# PRELIMINARY PLAN MEADOW LAKE INDUSTRIAL FILING NO. 1

A PART OF THE EAST HALF OF SECTION 9, TOWNSHIP 13 SOUTH, RANGE 64 WEST OF THE SIXTH PRINCIPAL MERIDIAN, COUNTY OF EL PASO, STATE OF COLORADO

PRELIMINARY OVERALL SITE PLAN MEADOW LAKE INDUSTRIAL FILING NO. 1

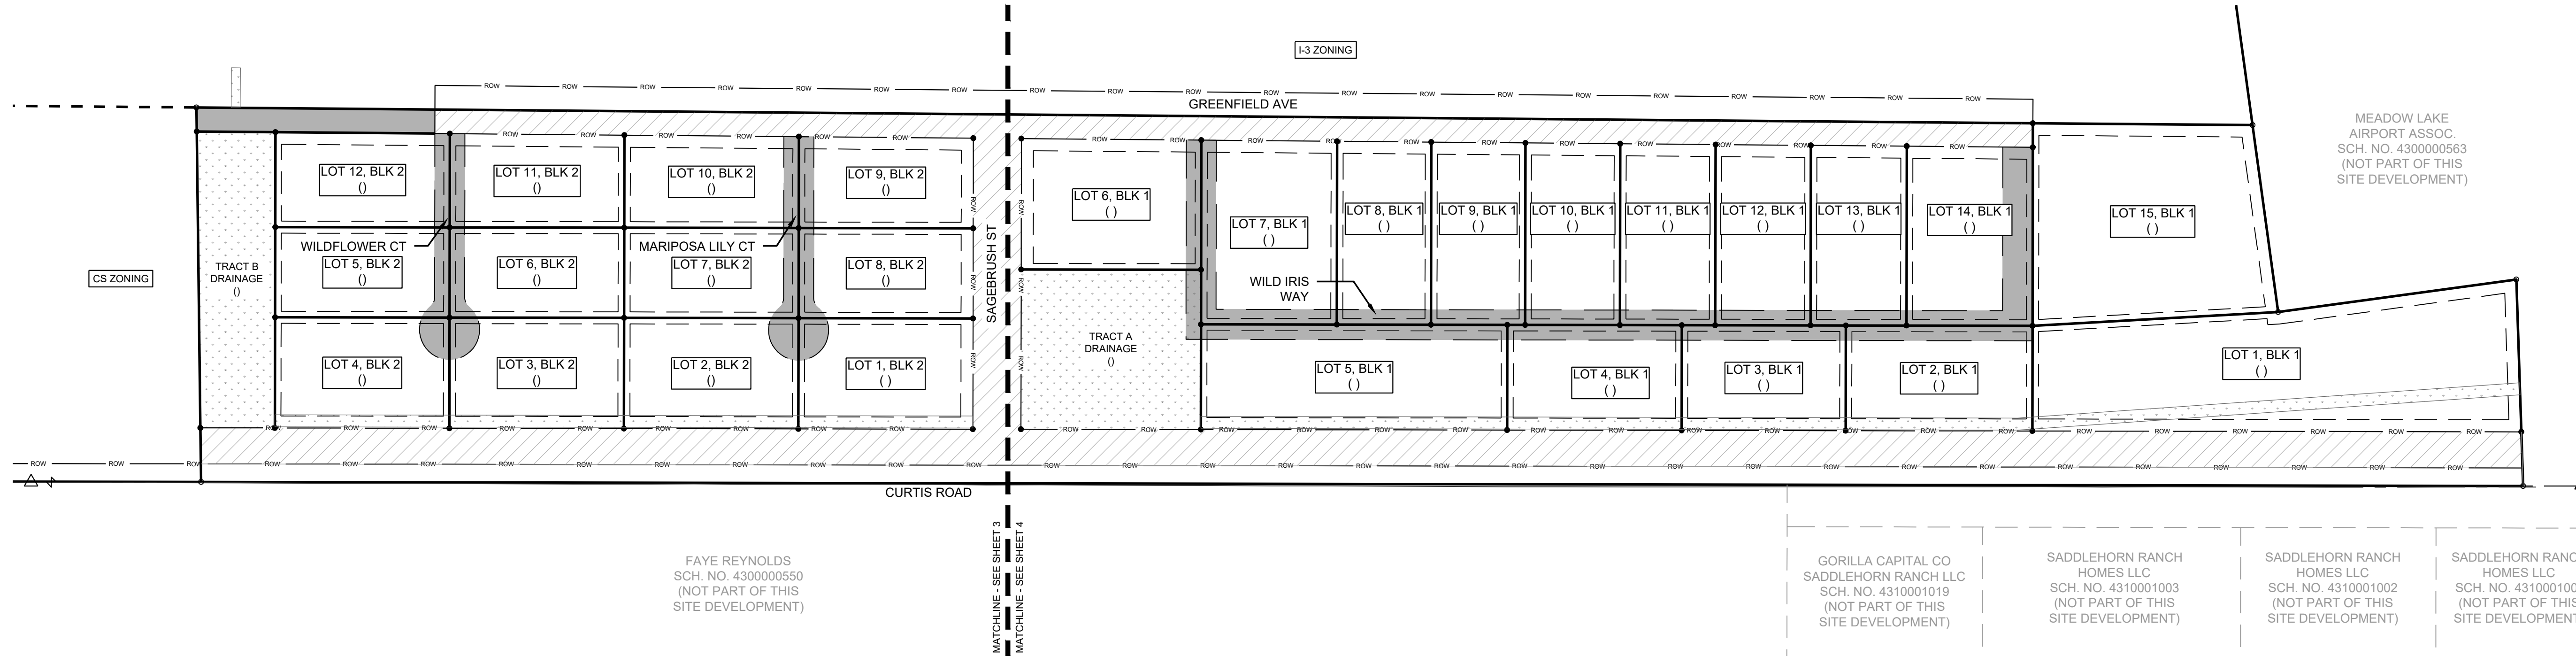
Include the location of property lines including location and boundaries of the subdivision since this subdivision is part of a larger area.

Revise to show permanent turnaround here if road is going to end. See ECM 2.3.8. If road will be extended in the future, provide temporary turnaround.

Revise to show permanent turnaround here if road is going to end. See ECM 2.3.8.

These notes should say "not a part of this subdivision"

Revise to show 72' of ROW dedication from centerline of Curtis Road that will be required for this development. The dedication should be along the entire frontage of the development.

Please also show and label the ROW preservation (18'). This will match what was determined with the Saddlehorn Subdivision to the north.

It is preferred that the acreages and square footages be displayed within the lots on pages 3-4, instead of in the table. This is more of a request than a requirement, but would help to clean up the plan and improve clarity. Please remove the block designation and label the lots as 1-27.

PRELIMINARY ENLARGED SITE PLAN MEADOW LAKE INDUSTRIAL FILING NO. 1

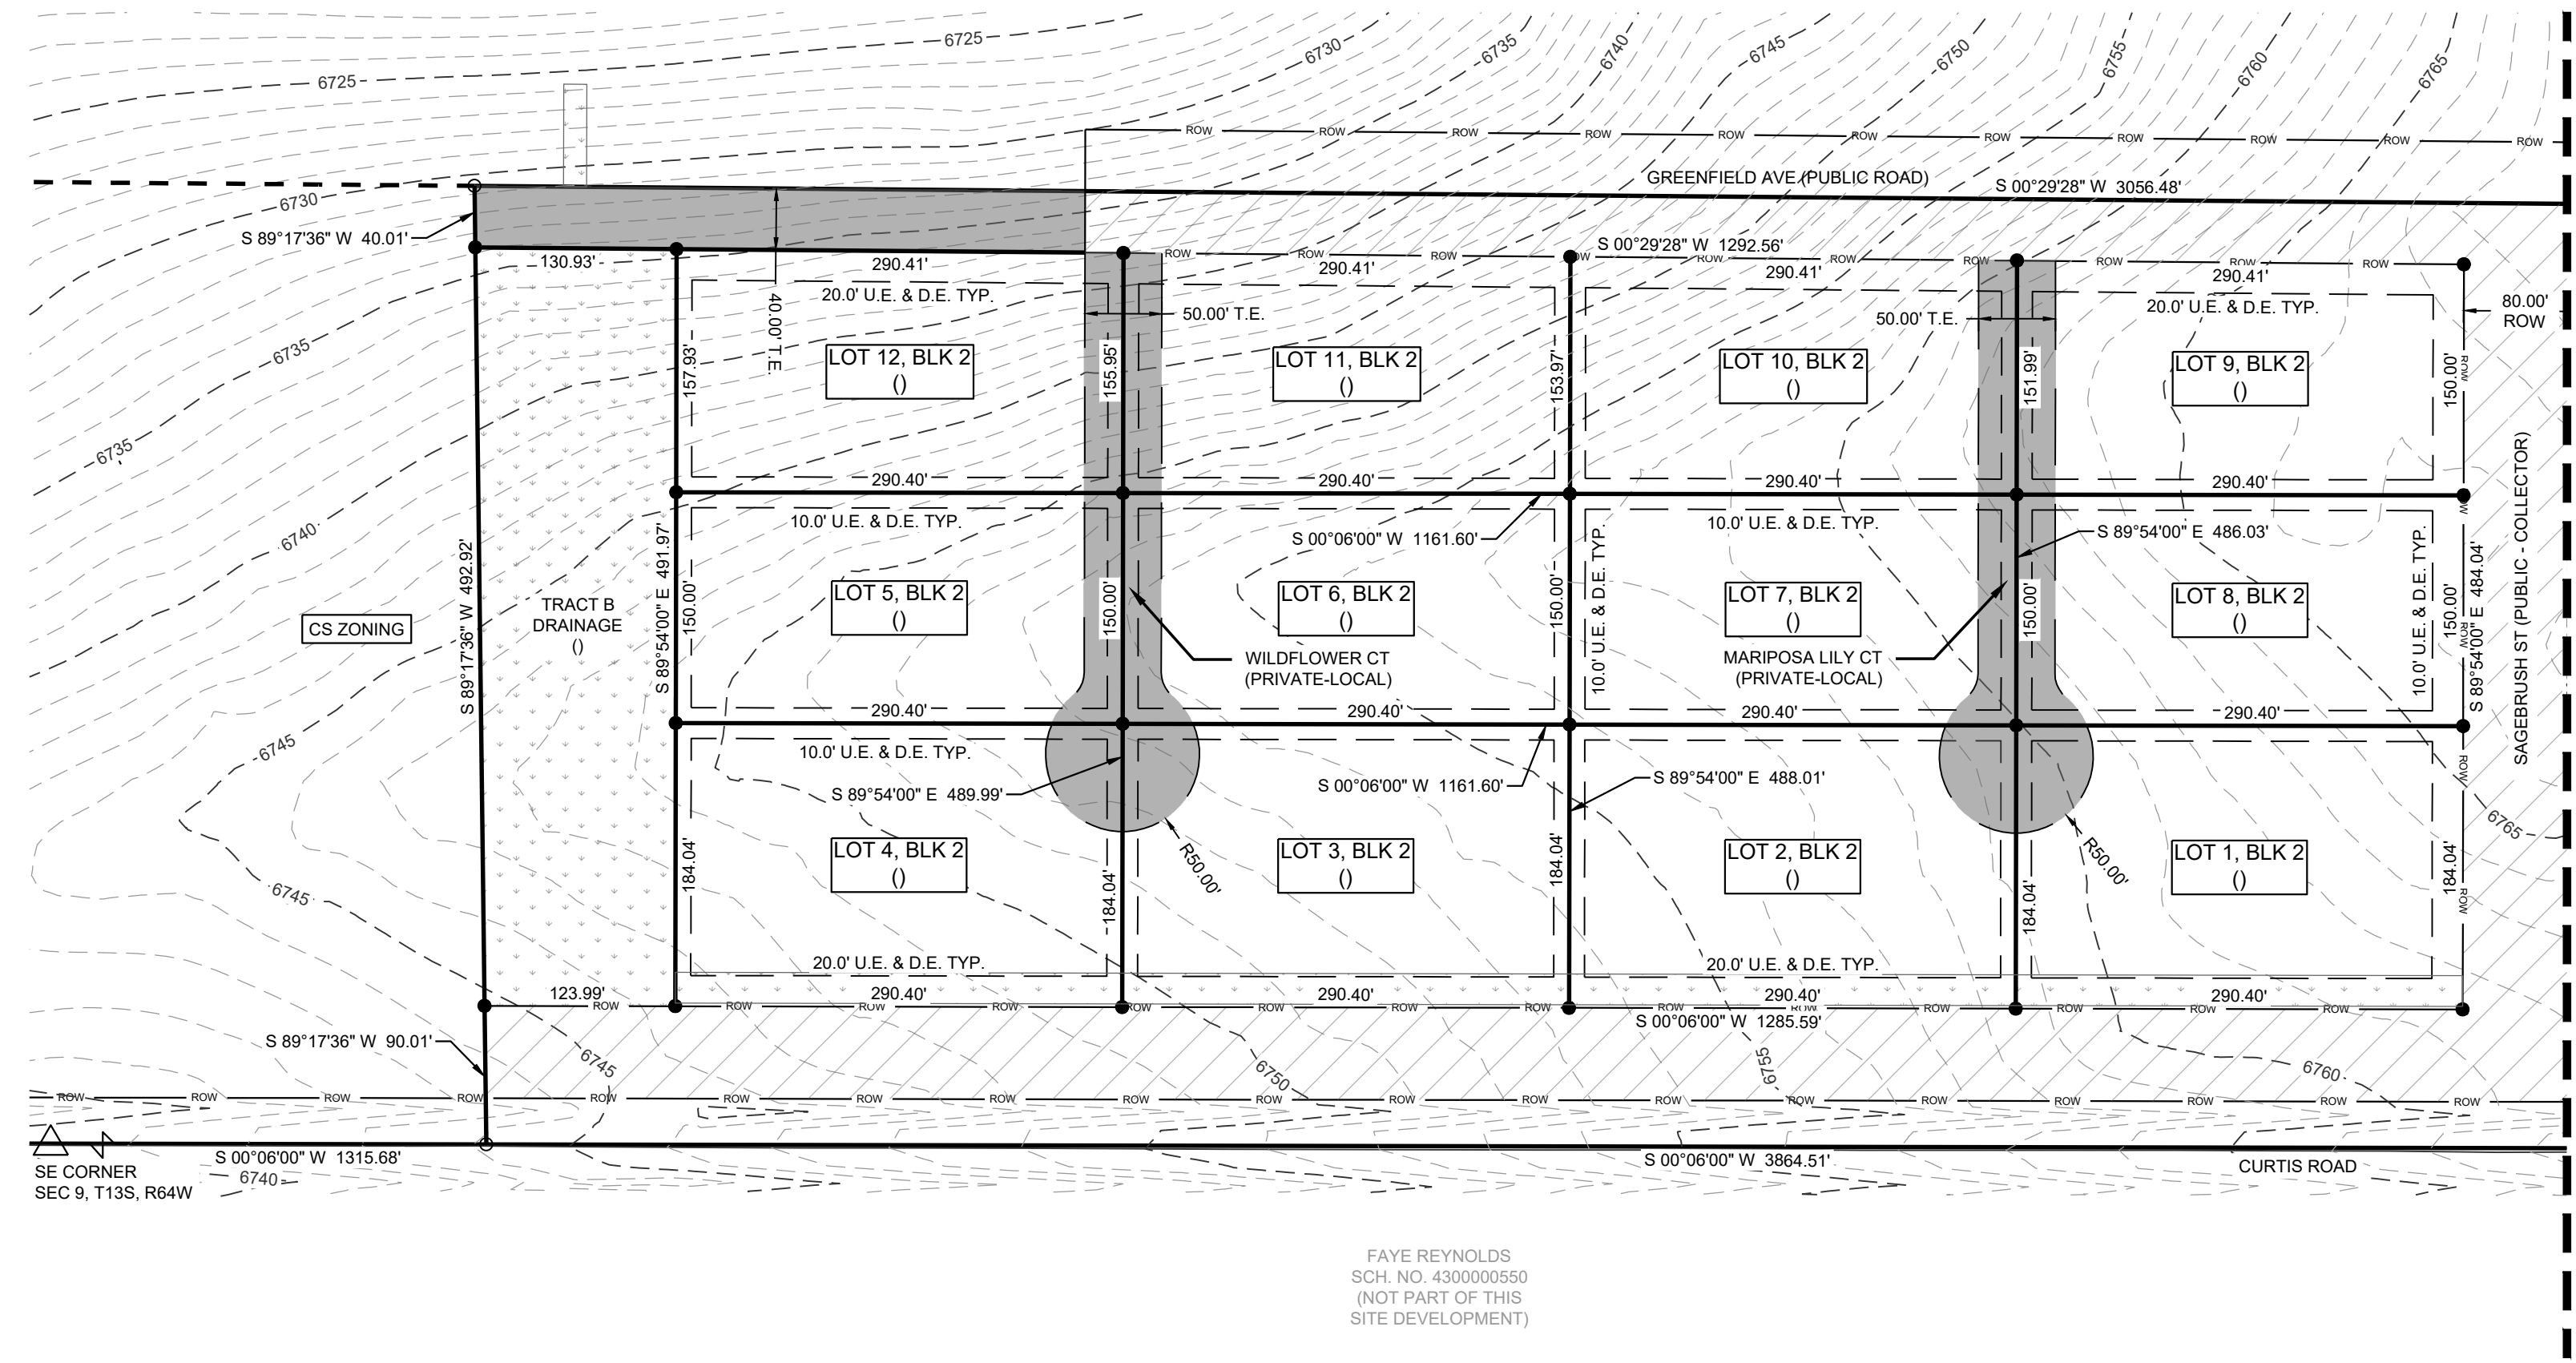
Why is only half of Greenfield Ave hatched as ROW? It looks like it dead ends into a private portion to the south.

coordinate with the drainage engineer regarding the width of the drainage easement at rear of these lots and update as needed.

The TIS identifies turn lane improvements at Curtis and Sagebrush. Please include these in the preliminary plan as well as any other improvements that are required/recommended by the traffic engineer.

PRELIMINARY PLAN

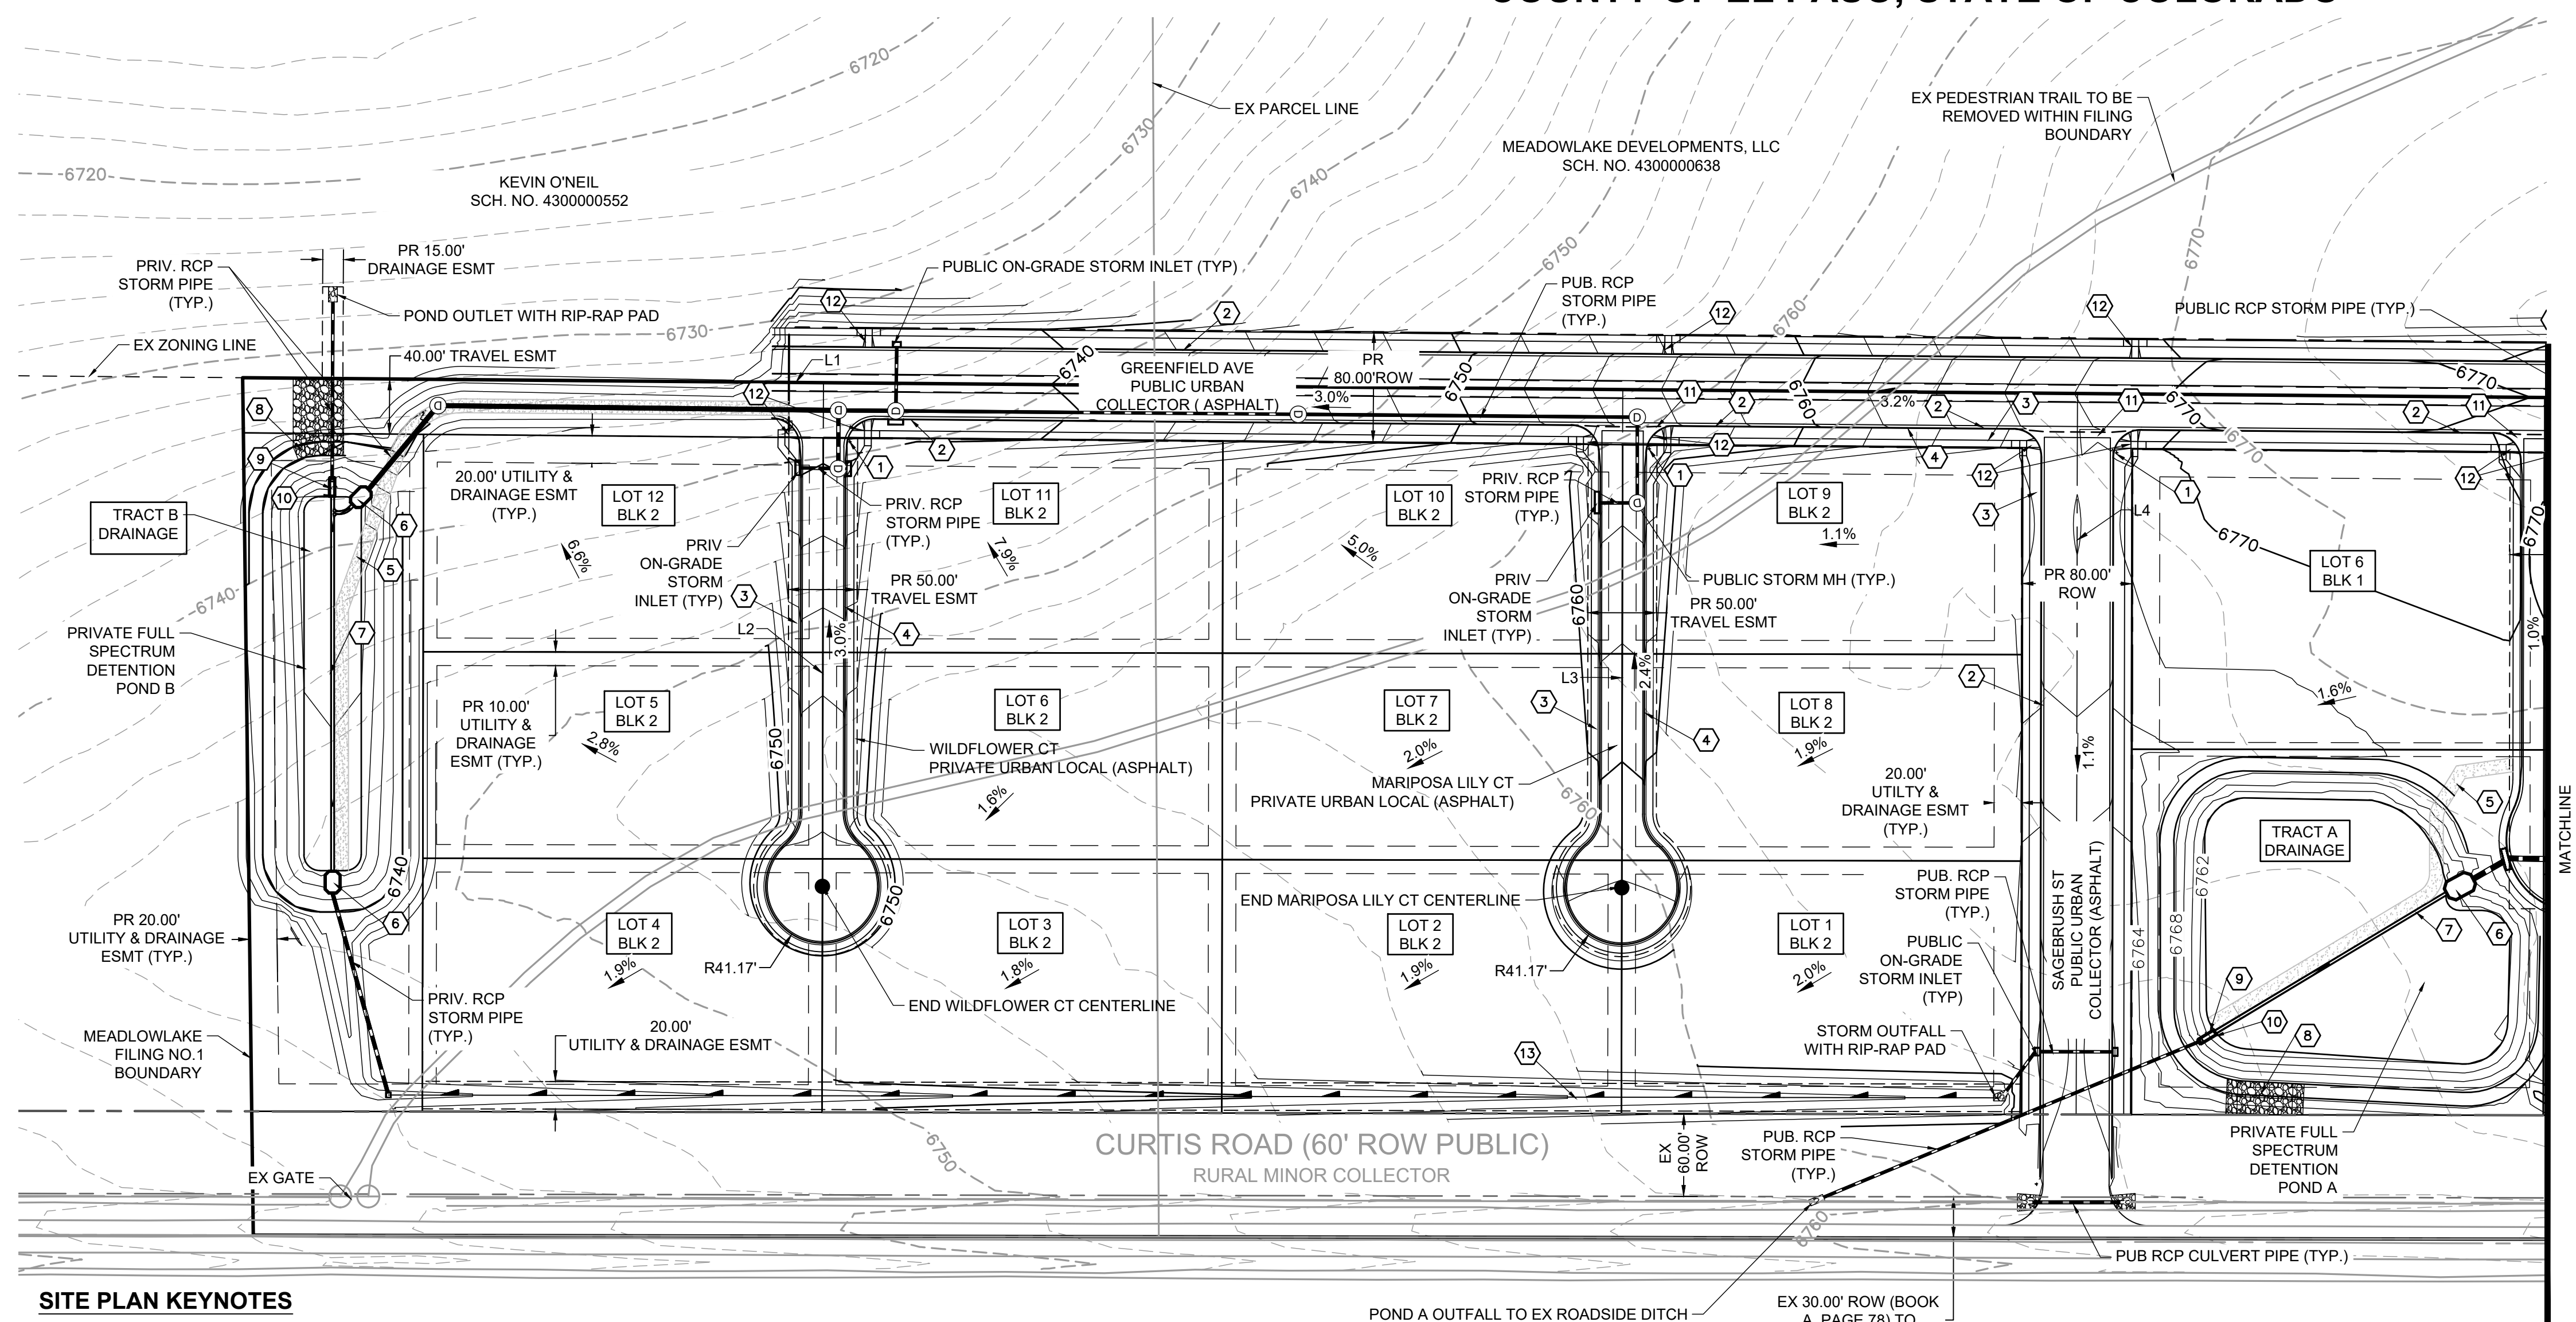
Depict the proposed fire hydrant locations.

Revise to include product/method that will be used to line the swale.

Update to show basecourse under curb.
